STATE OF NORTH CAROLINA  
DEPARTMENT OF TRANSPORTATION

September 27, 2004

Subject: **Application for Modification to Section 404 and Section 401 permits and Neuse Buffer Certificate** for the Northern Wake Expressway (I-540) from US 1 to US 64 in Wake County, Division 5. State Project No. 8.2401701, Federal Aid Project No. F-123-1(1), TIP No. R-2000 F&G; \$475.00 Debit Work Order 8.2401701, WBS Element No. 34365.1.1. NCDENR-DWQ Water Quality Certification Project No. 030114 and USACE Action ID 199920387.

The purpose of this submittal is to request a modification to the Section 404 permit and Section 401 Water Quality Certification and Neuse Buffer Certificate, specifically for Sections F&G. The modification for the permit is for several changes to jurisdictional and buffer impacts through construction modifications and to state discrepancies found by NCDOT personnel between the permit drawings and the construction plan sheets.

N.C. DEPT. OF TRANSPORTATION  
 DIVISION OF HIGHWAYS  
 WAKE COUNTY  
 PROJECT:  
 SHEET 39c OF 50  
 REV. 05/14/04  
 7/3/03  
 REVISED 10/25/04

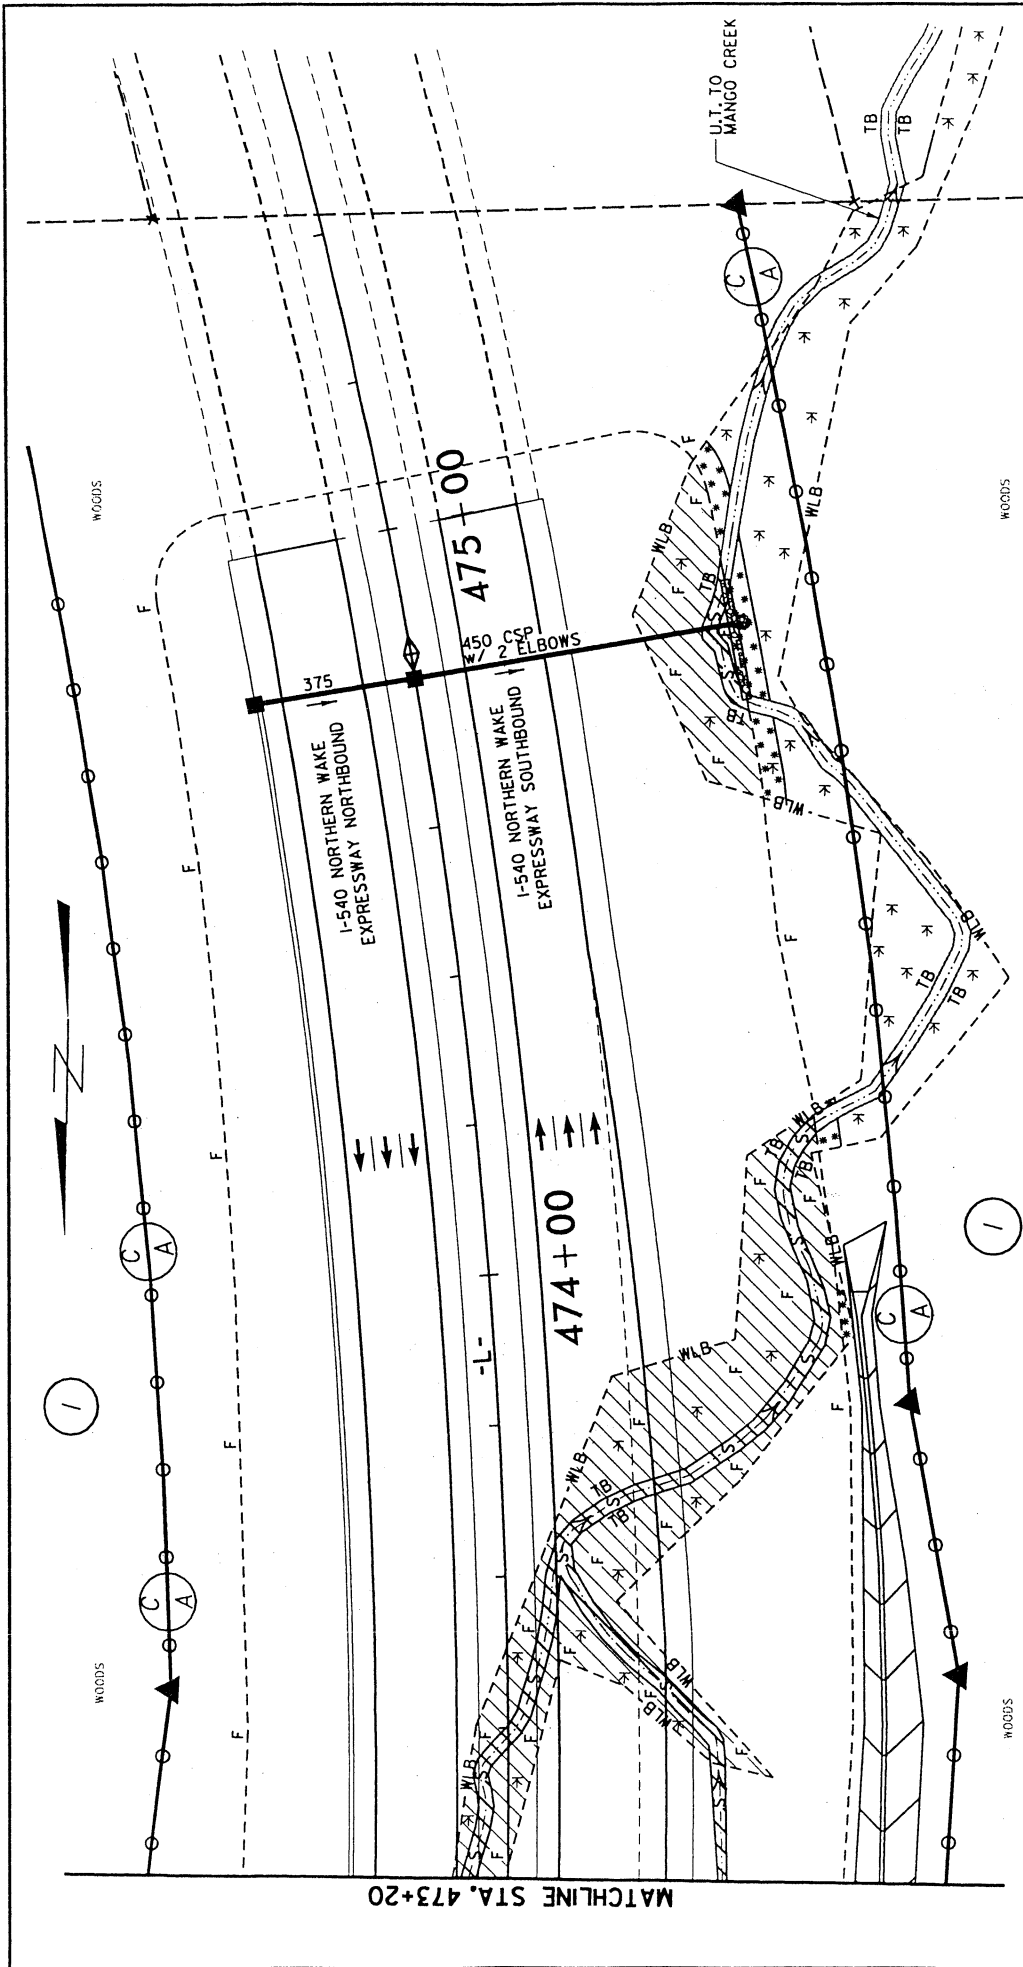
The Plan Sheet 17 (specifically Detail TT) depicts rip rap in the bottom of the head base ditches at the inlets of Structures 126 and 130. Permit Drawing 39c was revised to match the plan sheet, with Class B Rip Rap in both proposed head ditches. Original stream impact limits reflected in the approved permit cover both of these areas. Therefore, no additional jurisdictional impacts.

PLAN VIEW  
 SITE 5

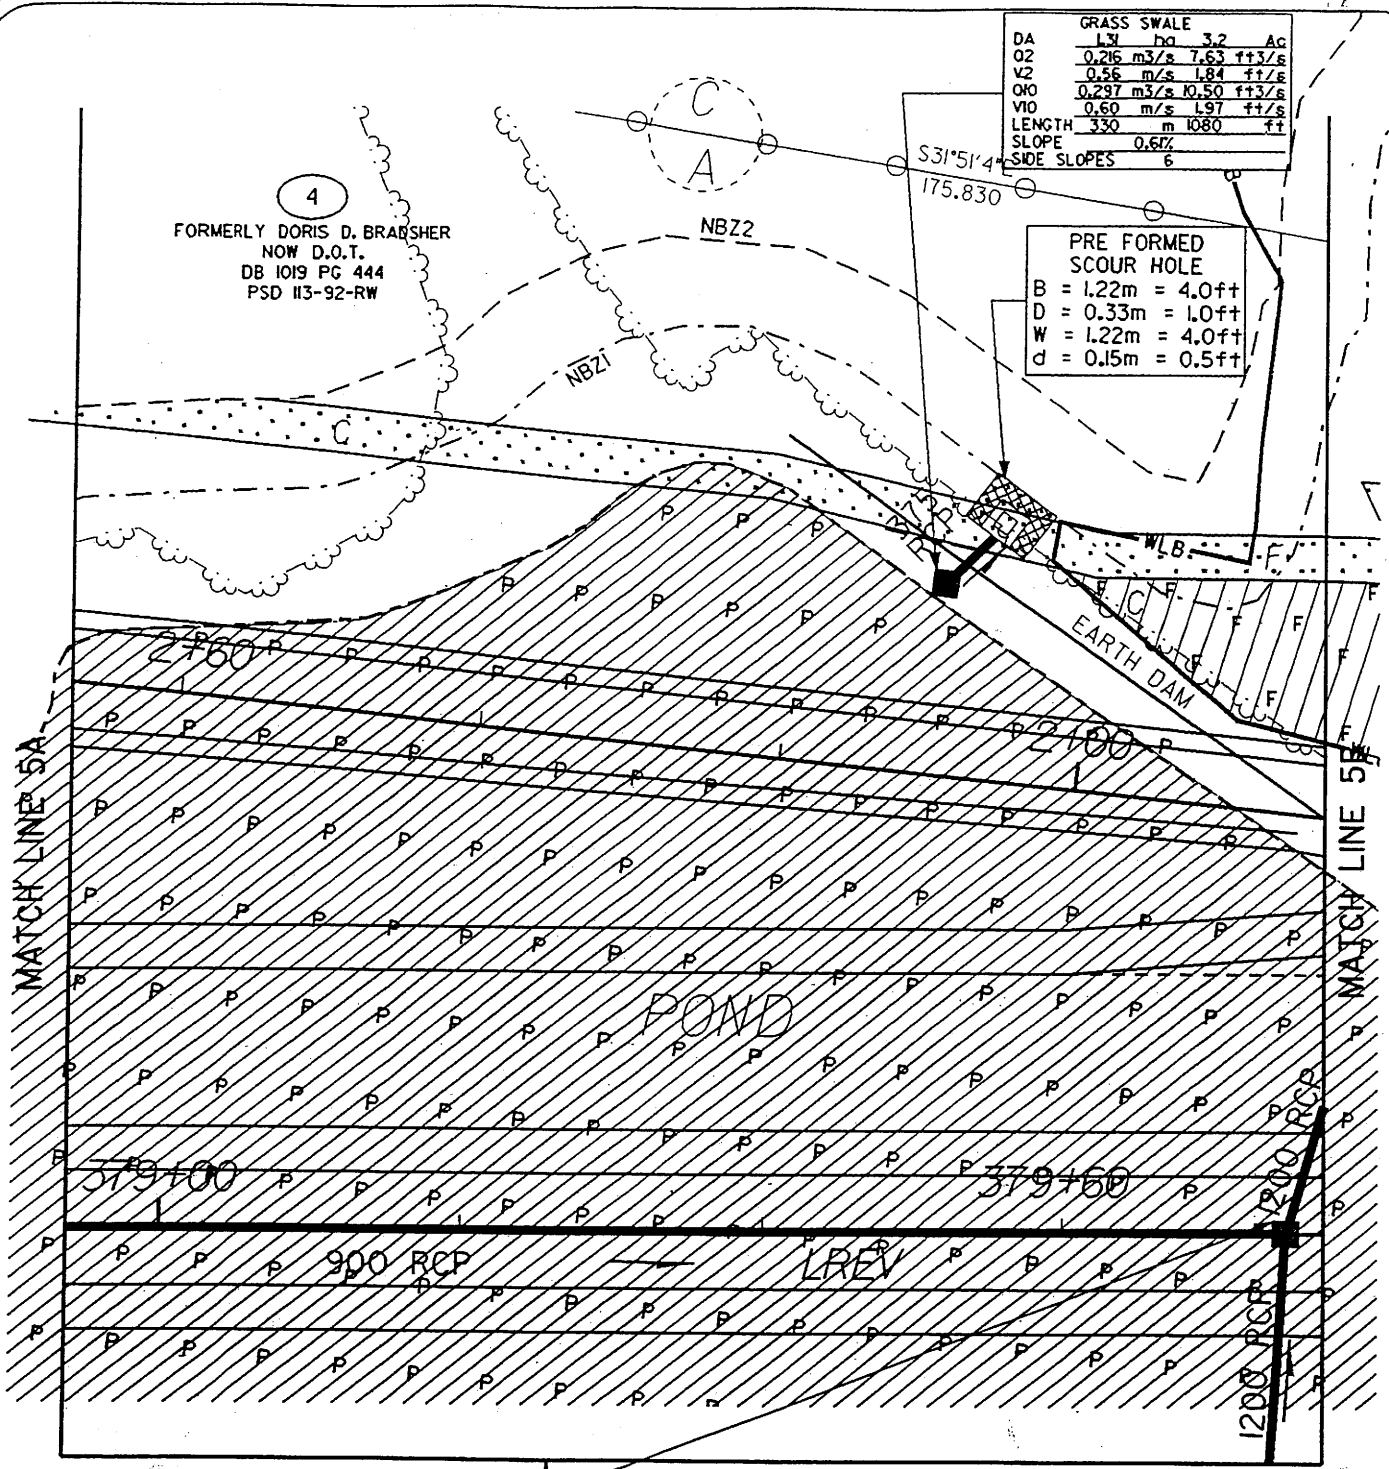
A pre-formed scour hole is proposed to be constructed beyond the original permitted area. The permit drawing was revised to reflect these additional buffer impacts. The impacts are 87 sq ft of mechanized clearing in Zone 1.

In addition, Plan Sheet 12 will be revised to reflect the correct dimensions of the pre-formed scour hole on the permit drawing.

SHEET 23 OF 90

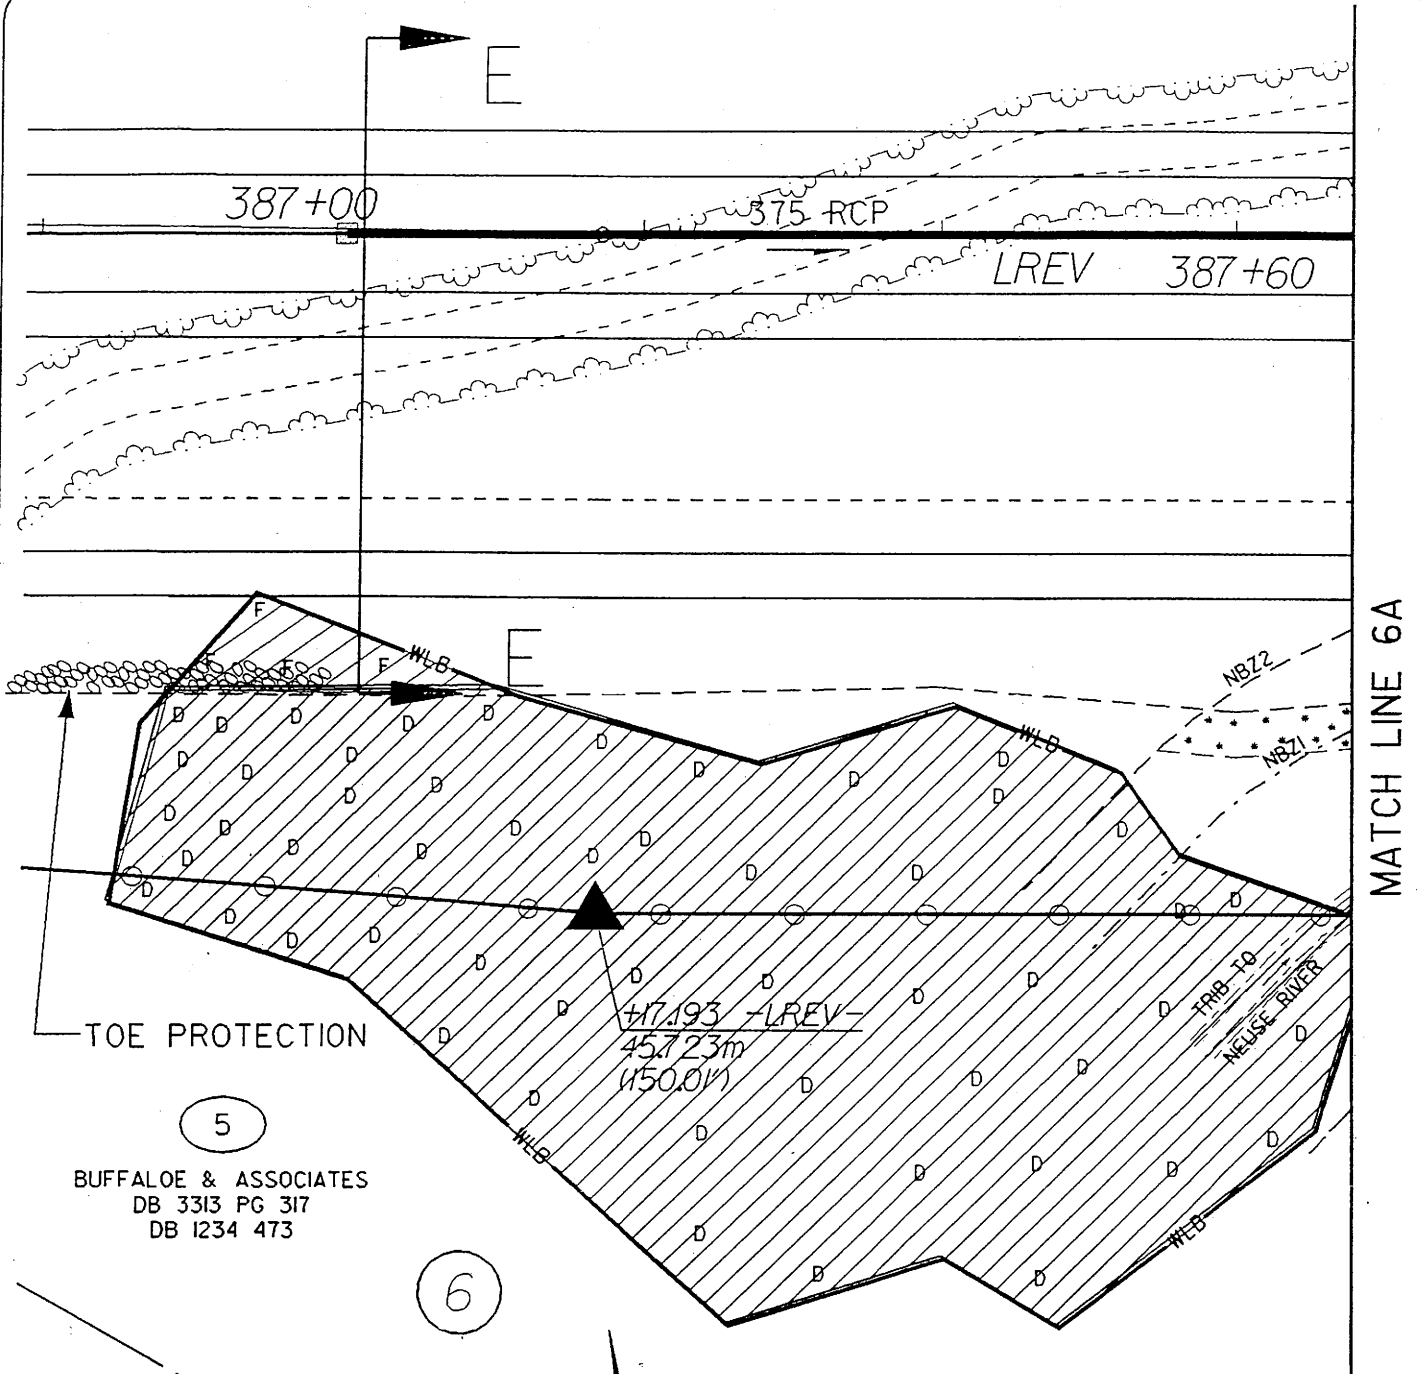
Permit drawing will be revised to reflect the proposed berm drainage outlet (BDO) as reflected on the plans. No jurisdictional impacts will be result from this addition.

SHEET 42 OF 90

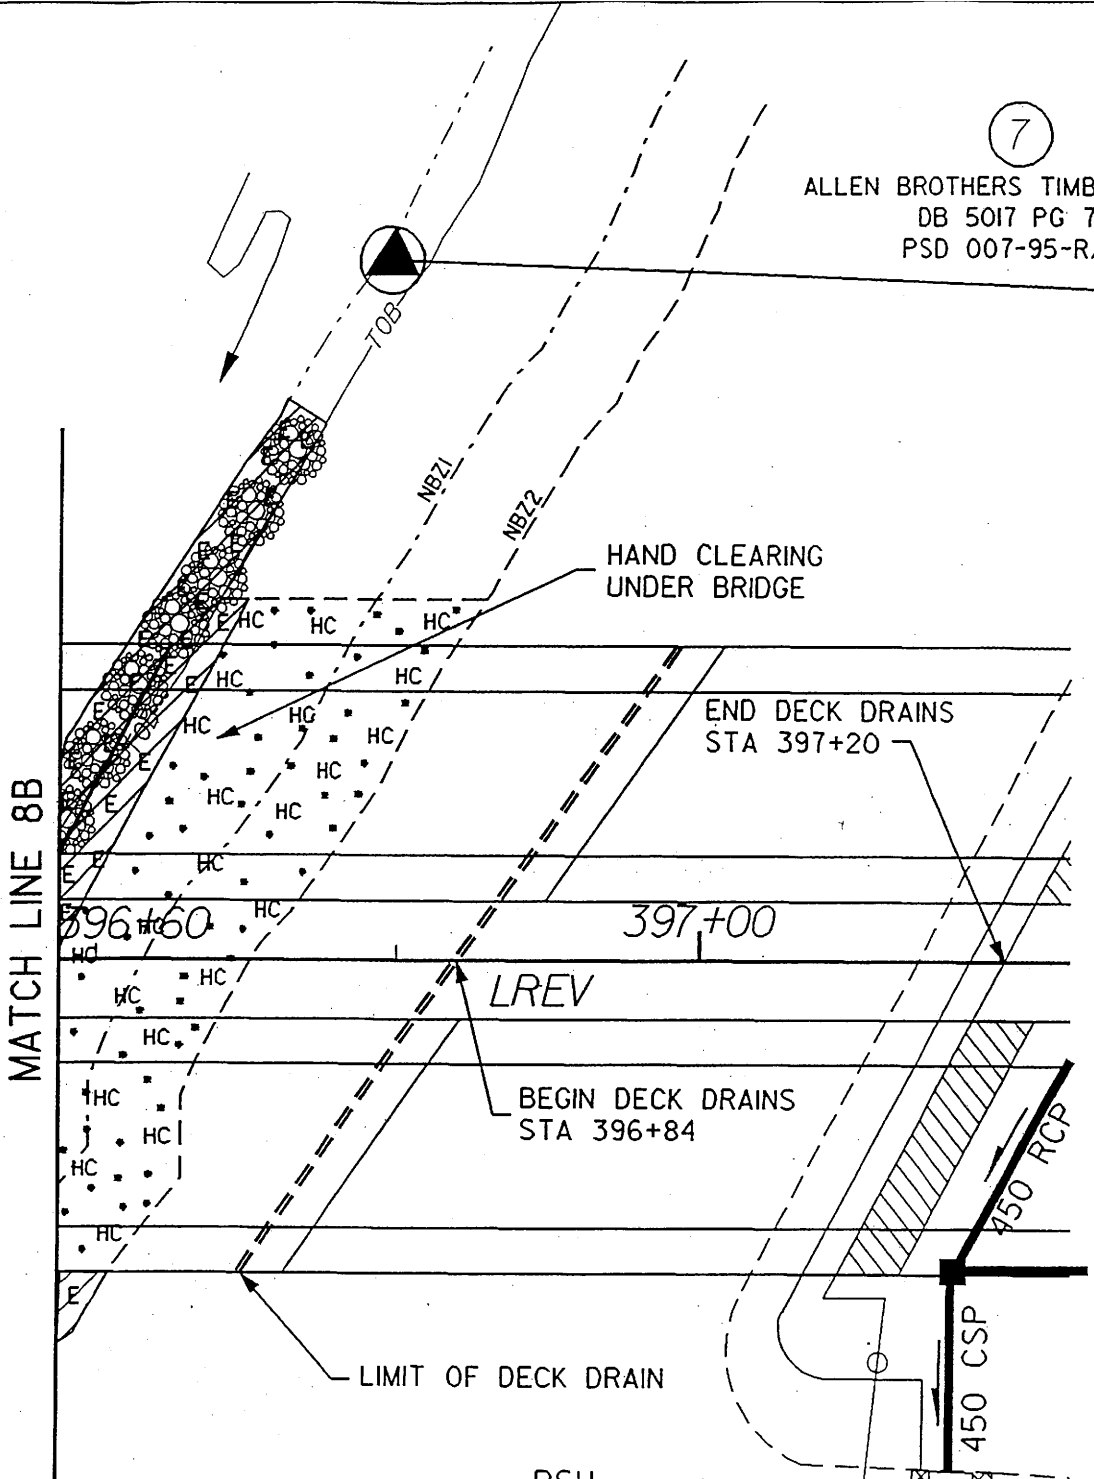
Permit Drawings 42 and 43 and buffer impacts will be revised to reflect excavation in Zone 1 along the East Bank of the Neuse River to allow for excavation and shaping of the existing bank and installation of the proposed Class II Rip Rap. The amount of excavation is 4835 sq ft in Zone 1. The hand clearing in the buffers was then reduced by 3354 sq ft.

**PLAN VIEW**  
**SITE 2**

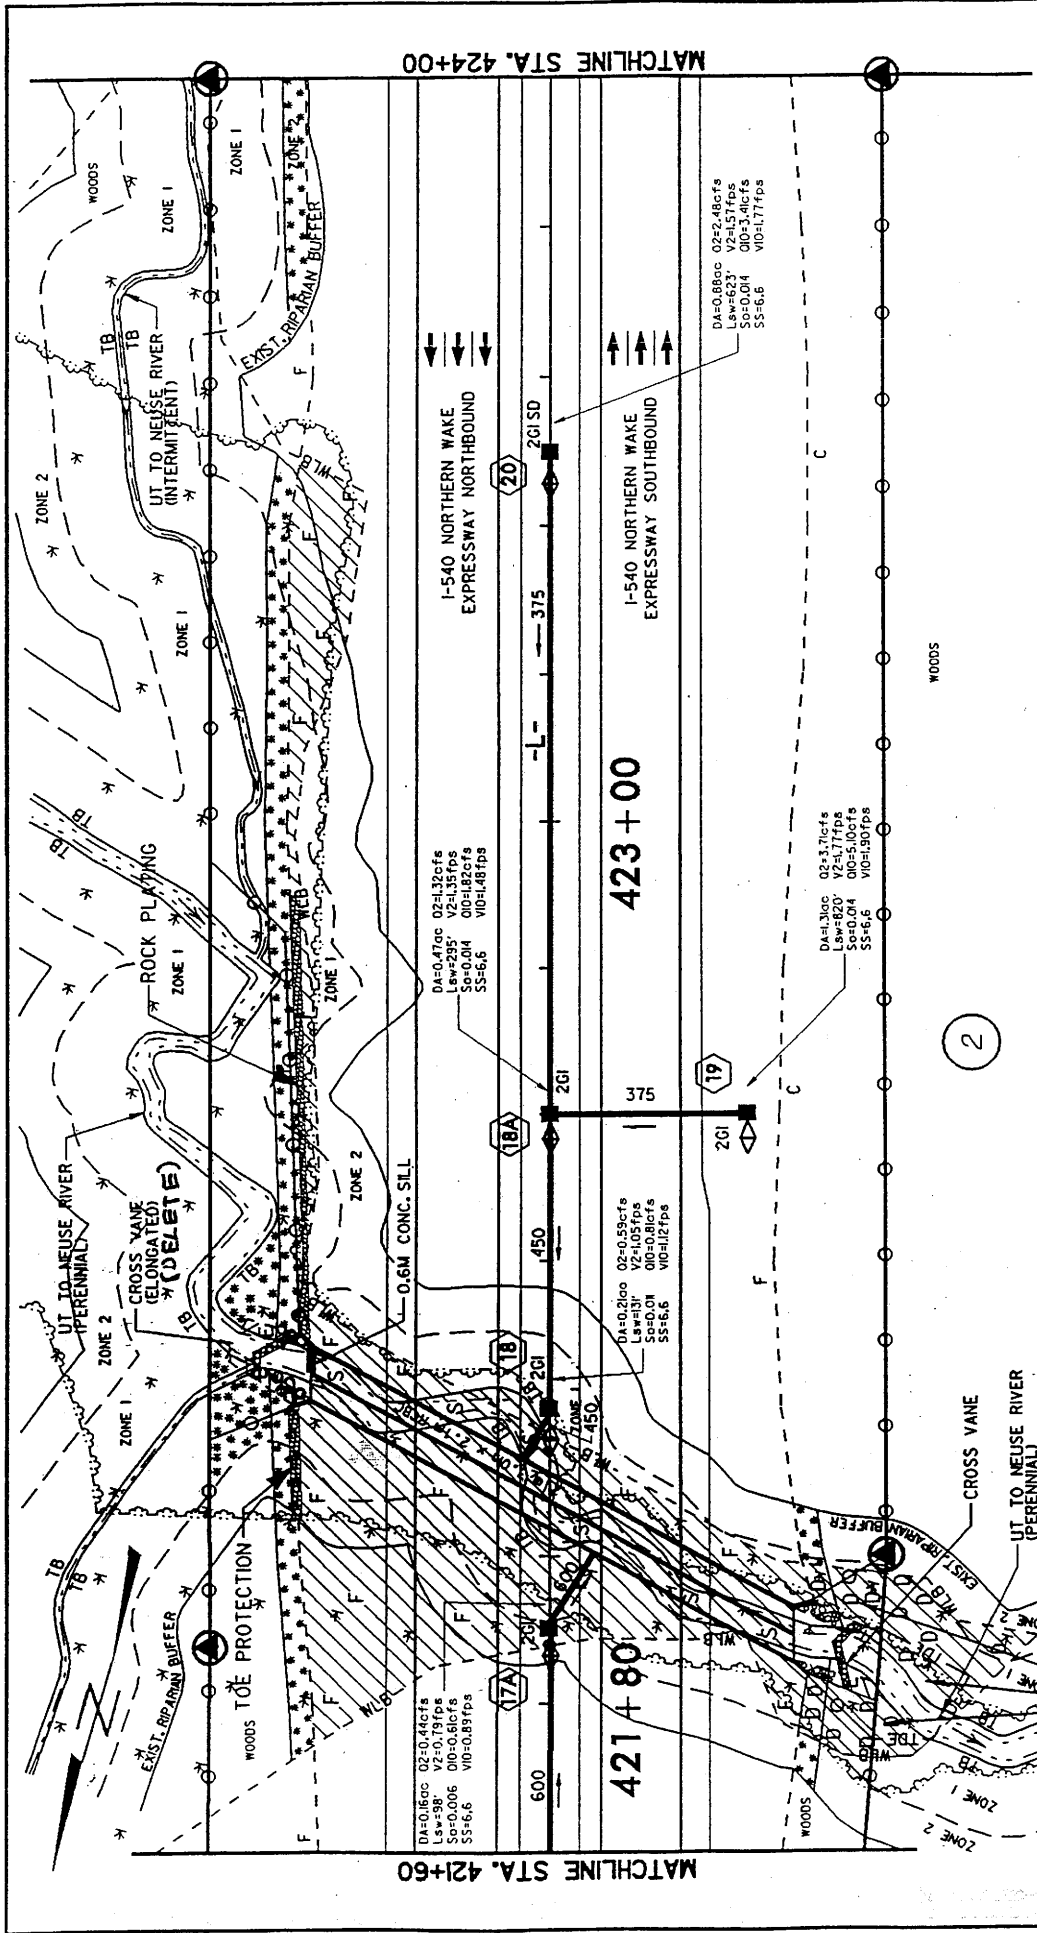
Permit Drawing 9 was revised to reflect the proposed rock cross vane in the correct location to agree with the Plan Sheet 6. It was also revised to reflect additional mechanized clearing impacts to Zone 1 of the buffers (to the proposed R/W / C/A fence) to allow room for installation of the proposed cross vane at the inlet of the box culvert. The additional buffer

impacts of mechanized clearing in Zone 1 are 741 sq ft. The additional mechanized clearing will also have permanent wetland impacts of 0.042 ac.

No revisions to the permit drawing will be required at the outlet of the box culvert due to the overlap of buffer and wetlands. The mechanized clearing limits were included in the original wetland and buffer impacts in the approved permit. Additional buffer impacts to Zone 1 within the wetland boundary from the approved mechanized clearing line out to the C/A fence and the limits of the TDE will be added to the impact summary sheets (0.021 ha) (2265 sq ft). Wetlands will also be permanently impacted by this action. Wetland impacts are 0.052 ac.

Also, Permit Drawing Sheet 9 was revised to reflect the addition of toe protection from Sta. 422+05 –L- It. to end of the proposed culvert wing wall at approximately Sta. 422+20 –L- It. The addition of Rock Plating along the proposed fill slope from approximately 422+30 –L- It. to 422+90 –L- It. will also be reflected. A construction revision to Plan Sheet 6 has been revised to reflect the addition of the toe protection and the new proposed rock plating of the fill slope. No change in jurisdictional or buffer impacts for either of these additions will be required based on discussion with the resource agencies.

Bedrock in the streambed is located at the inlet of the proposed culvert at this Site. During a field visit with Division 5 personnel and NCDWQ representative John Hennessy on September 21, 2004 it was approved that the cross vane shown on Permit Drawing 9 at the inlet of the culvert will not be feasible to construct. The permit drawing and plan sheet are revised. No jurisdictional impacts will occur.
